From: Laura Gibbons
Sent: 20 July 2018 15:43
To: Planning.Responses
Subject: RE: Planning Consultation on: EG/37/18/DOC

Engineers Comments Regarding Condition 3

APPLICATION **EG/37/18/DOC**

Description of Works: Approval of details reserved by condition following the grant of EG/14/18/HH relating to condition 3-surface water drainage.

Client	Kate Edney
Drawing Title	Surface Water Drainage

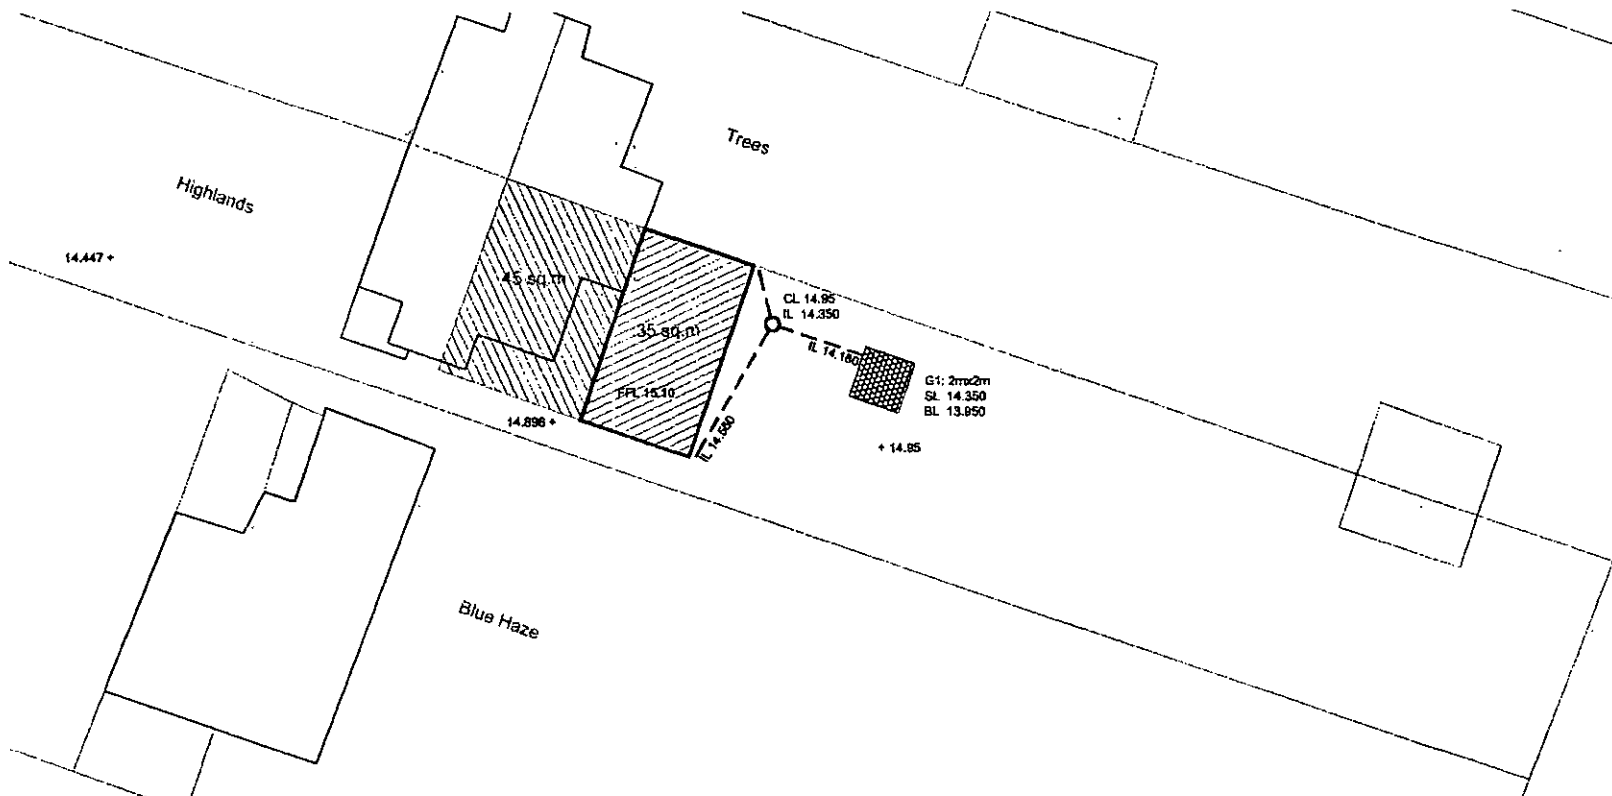
The groundwater monitoring and infiltration testing submitted were not completed in the winter. However, on review of neighbouring applications it is apparent that the parameters/ constraints used are in line with winter tests in close proximity to the site. The invert level of the proposed infiltration structure has been set high, and is above the maximum recorded ground water level on neighbouring applications. The infiltration rate used is better than that found on neighbouring developments, however a large factor of safety has been applied to the calculations for the drainage design for this application.

Therefore, based on the supplied information, I recommend that condition 3 is discharged.
